REQUEST

Current Zoning: UMUD-O (uptown mixed use, optional)
Proposed Zoning: UMUD-O SPA (uptown mixed use, optional, site plan amendment)

The petition proposes to modify an approved plan to allow additional signage for the Hearst Tower in Uptown.

REZONING PETITION 2020-064

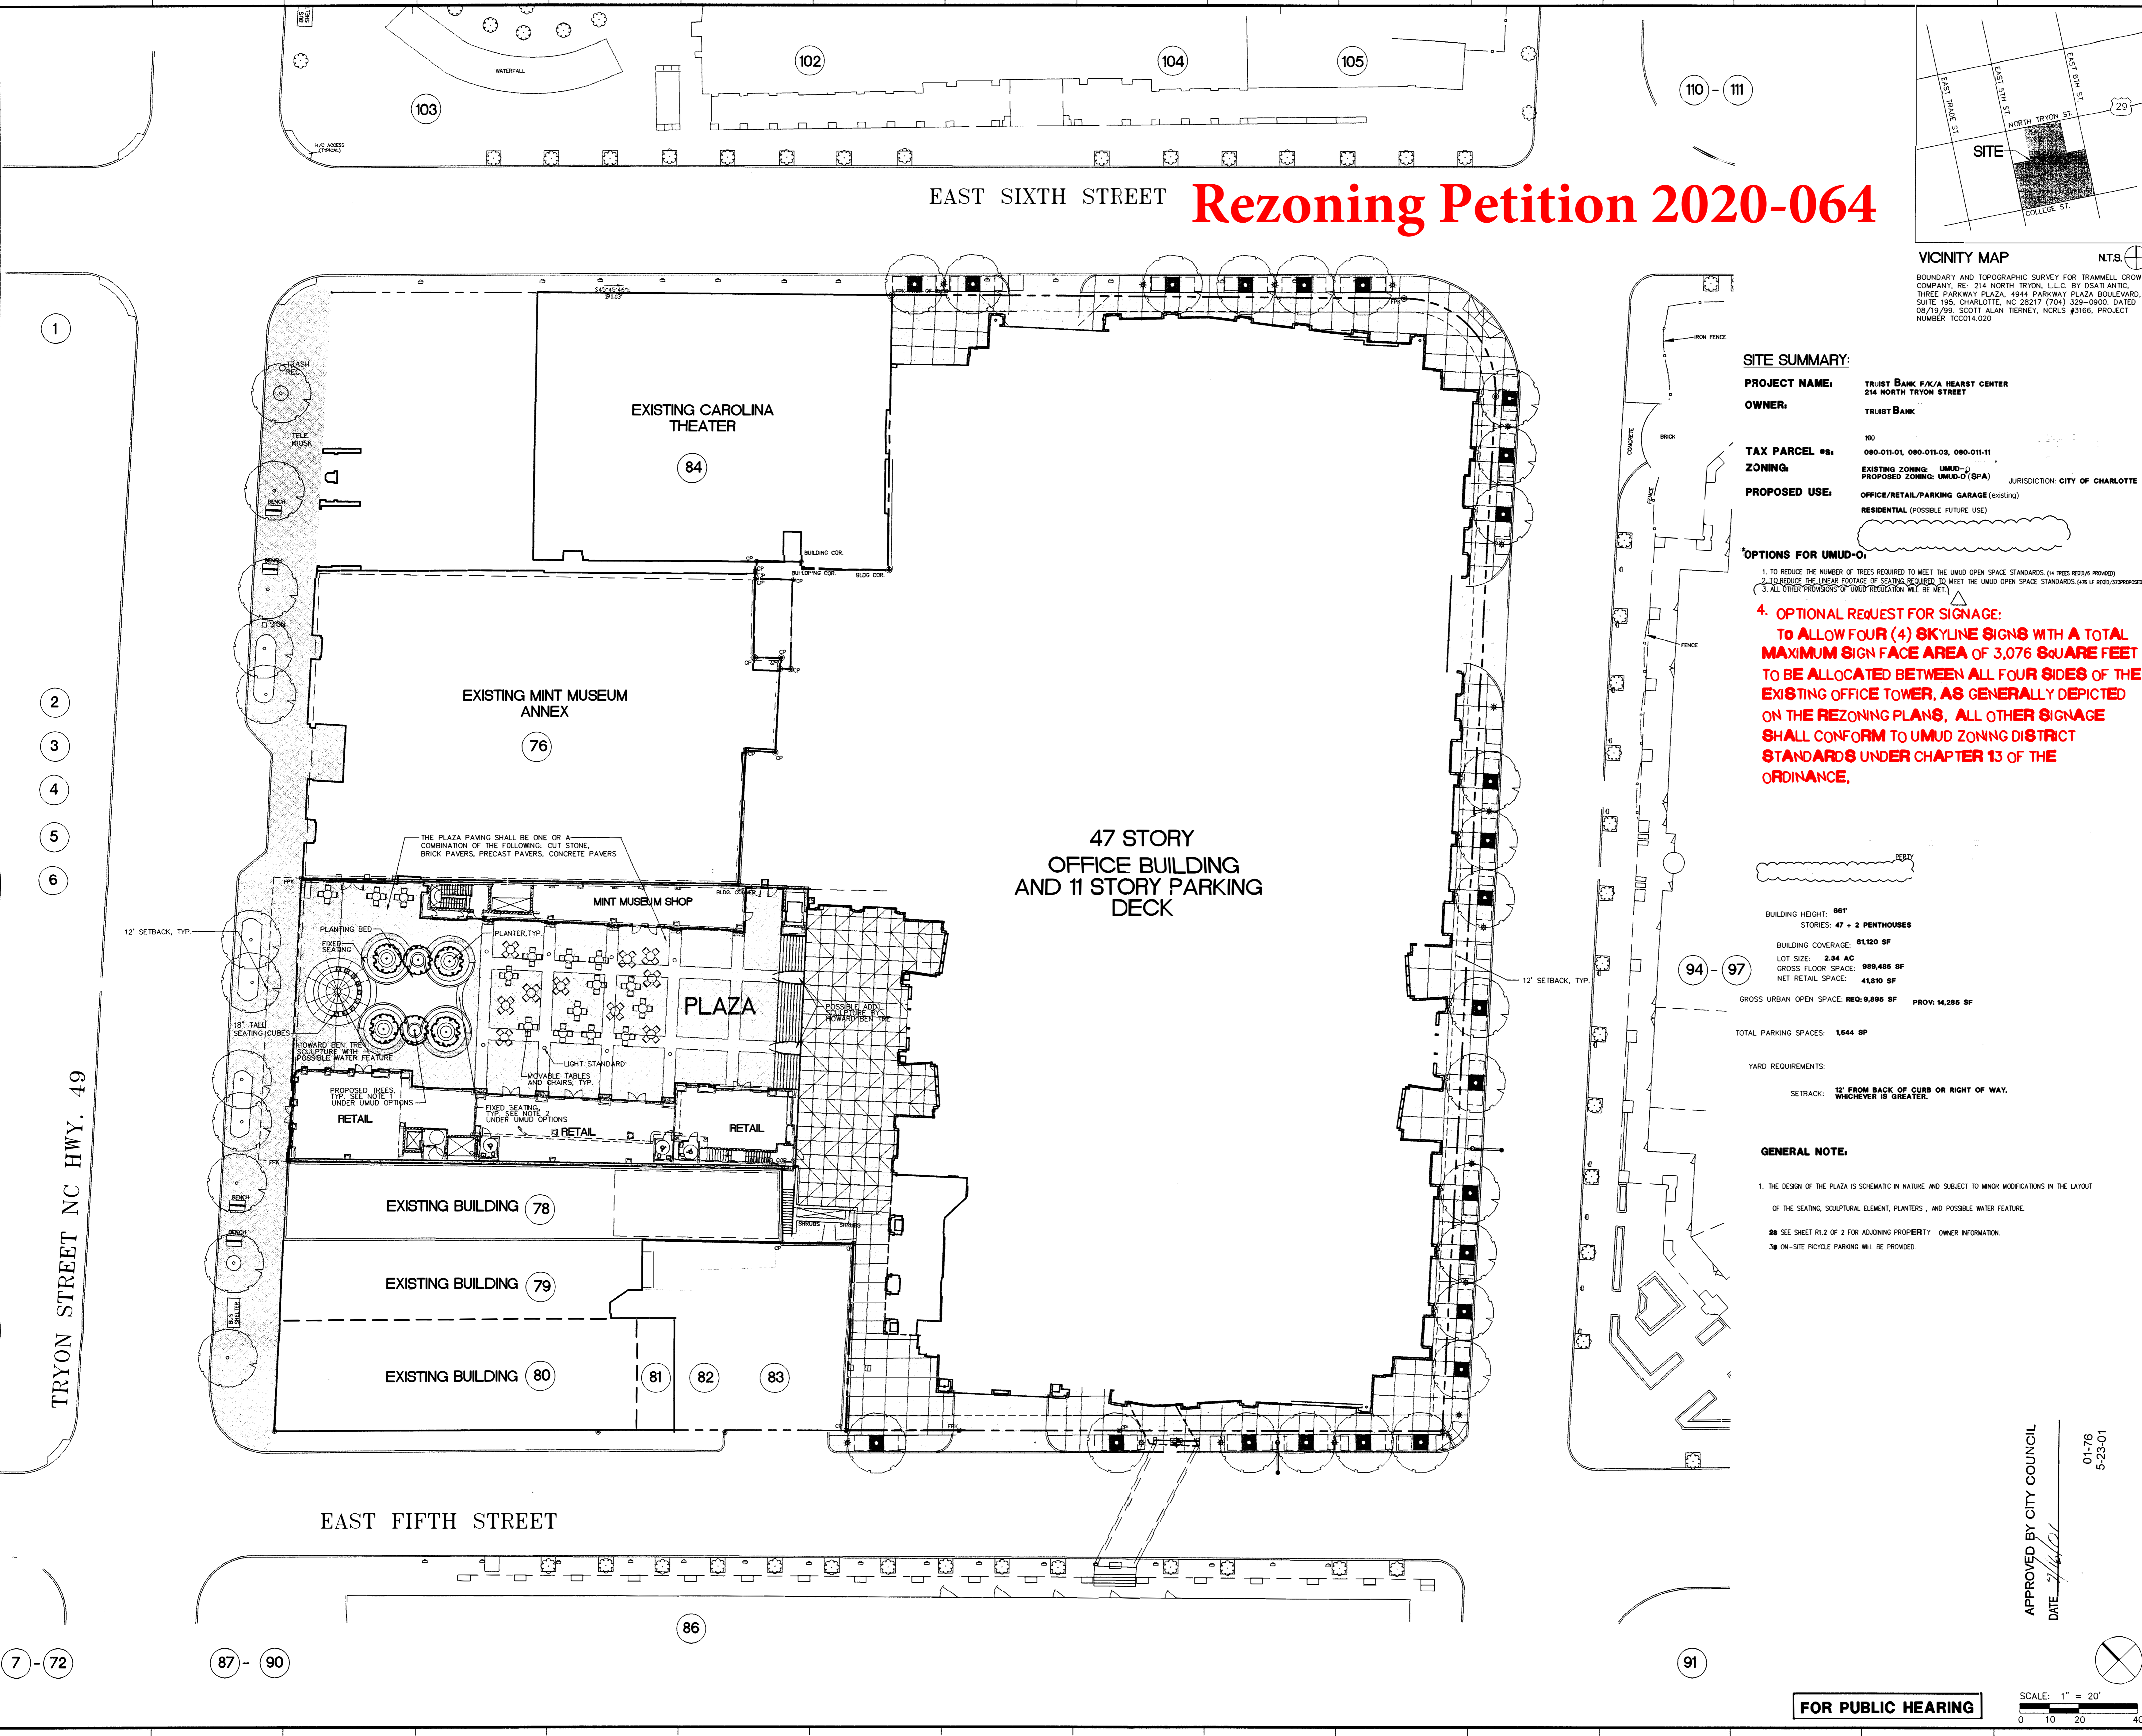
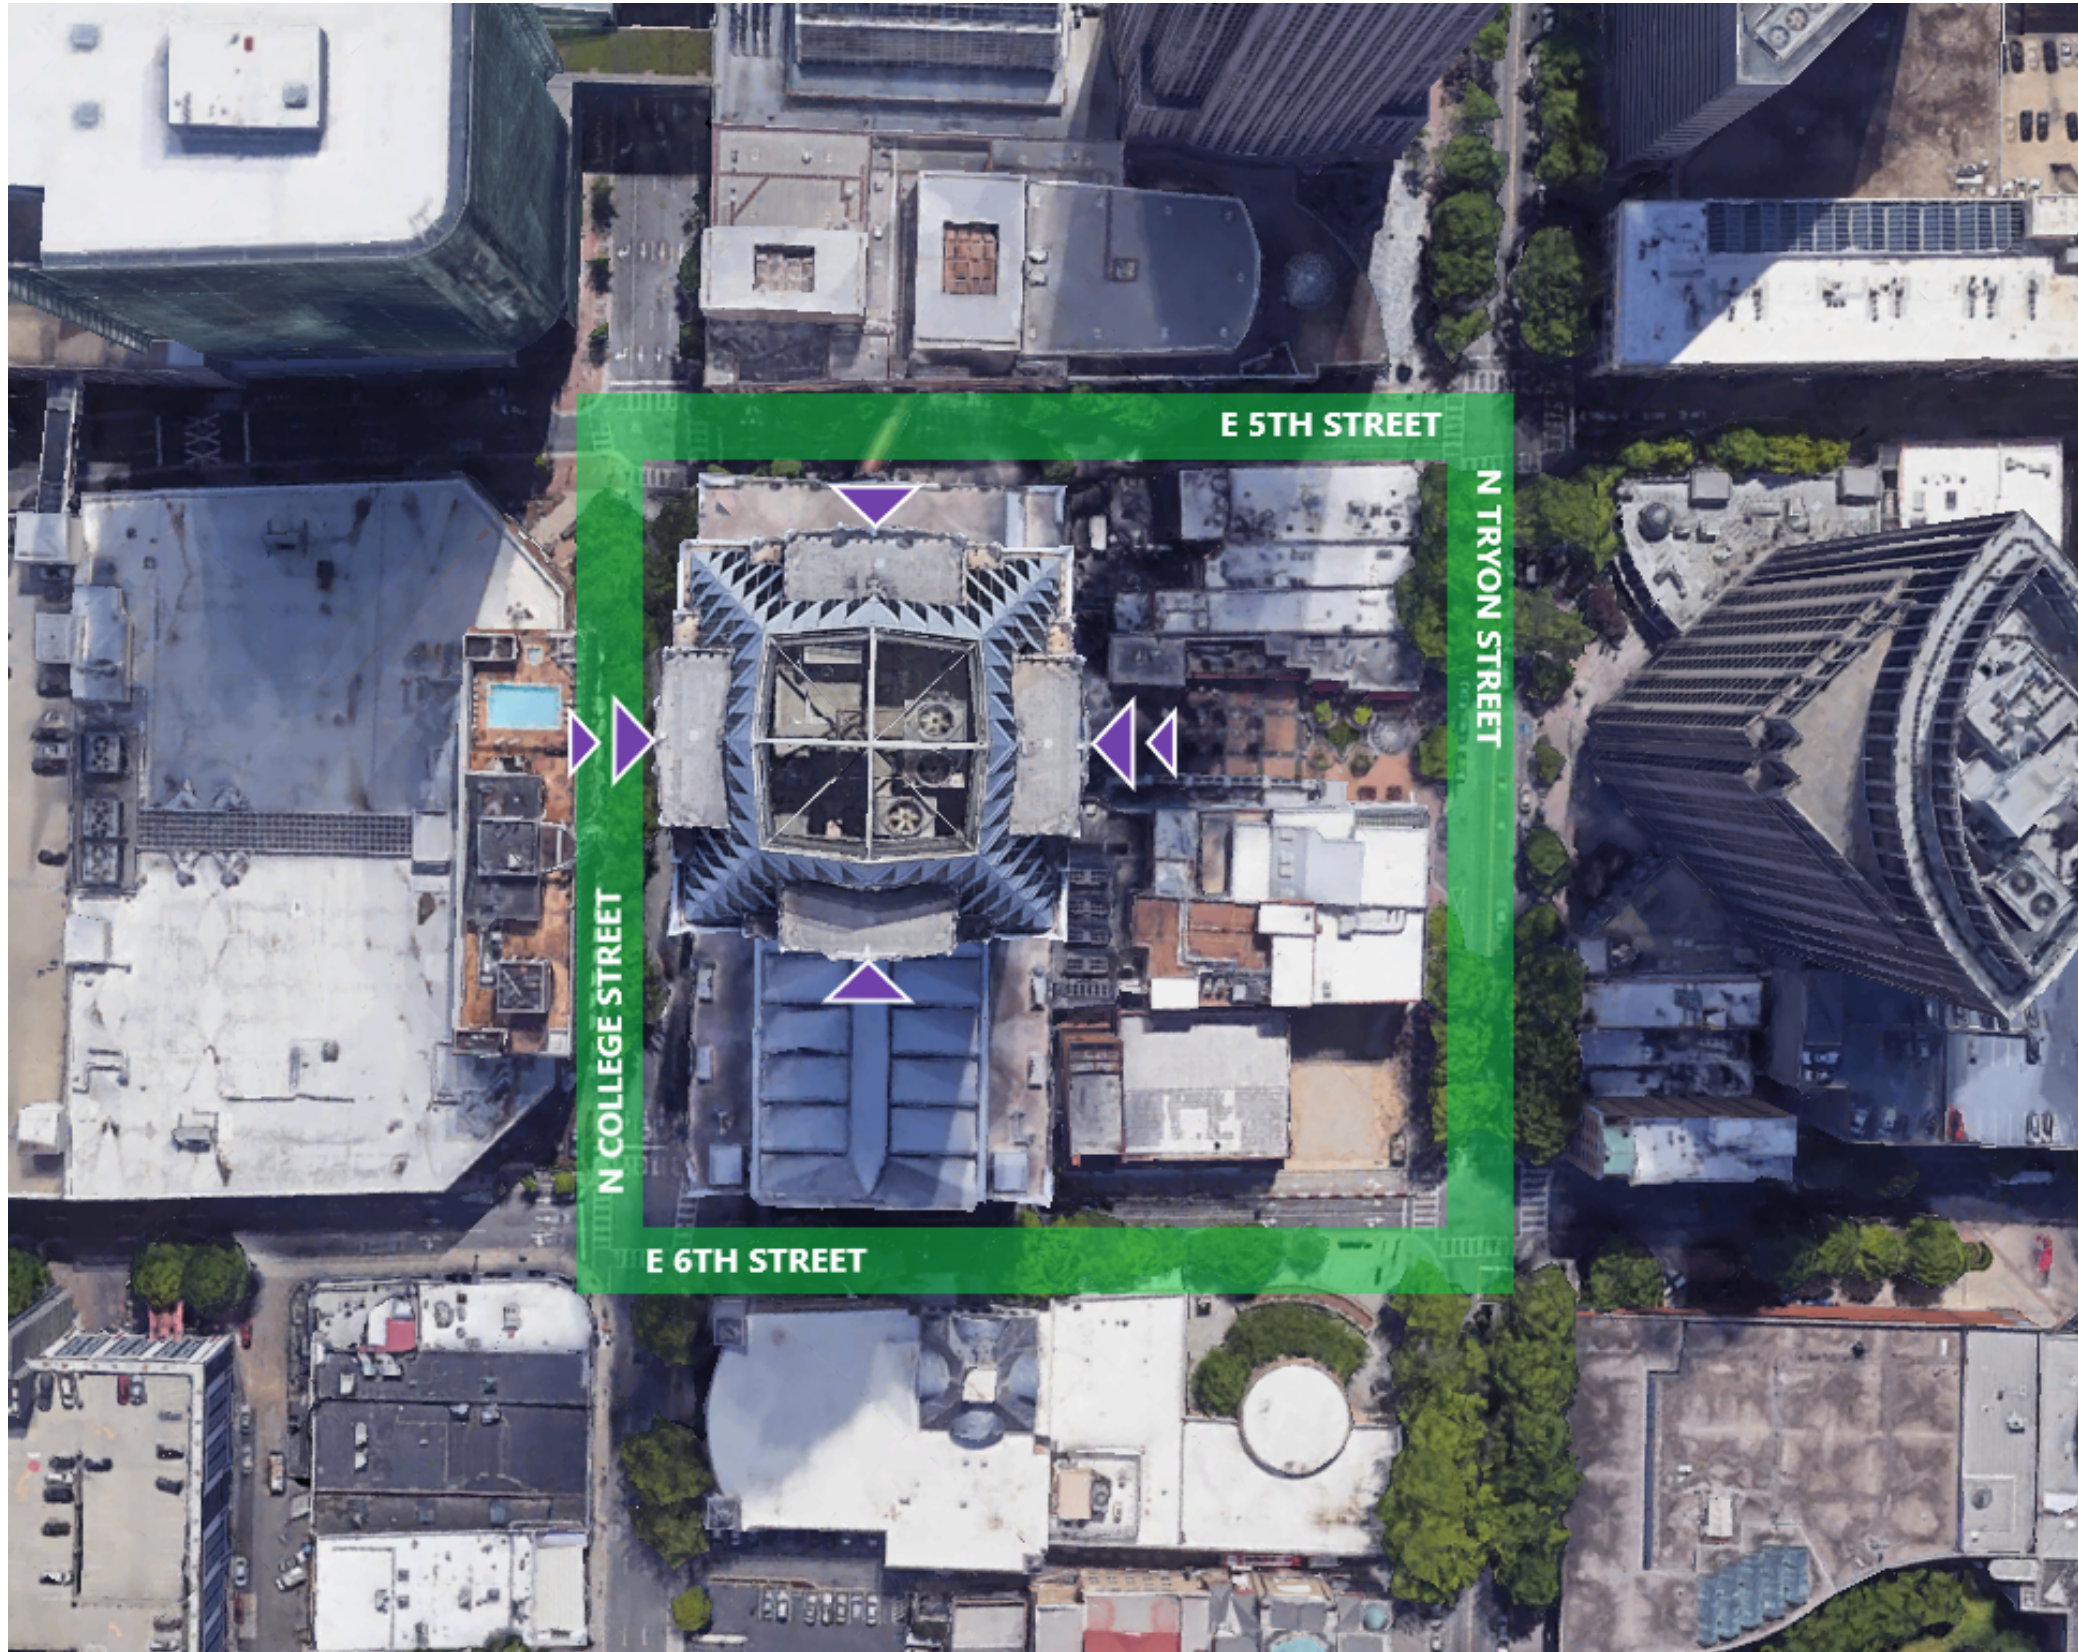
1. ~~Label each sheet 2020-064.~~ Addressed
 2. ~~Note proposed zoning is UMUD-O SPA.~~ Addressed
 3. ~~Place signage optional provision request on the site plan.~~ Addressed
 4. ~~Update ownership information on the site plan.~~ Addressed
 5. ~~Ensure optional provision language references the correct chapter in the ordinance.~~ Addressed
 6. ~~Ensure all entitlements under 2001-076 are noted in this plan.~~ Addressed
 7. ~~Remove heading "approved rezoning petition 2001-076" and reference in language.~~ Addressed
-
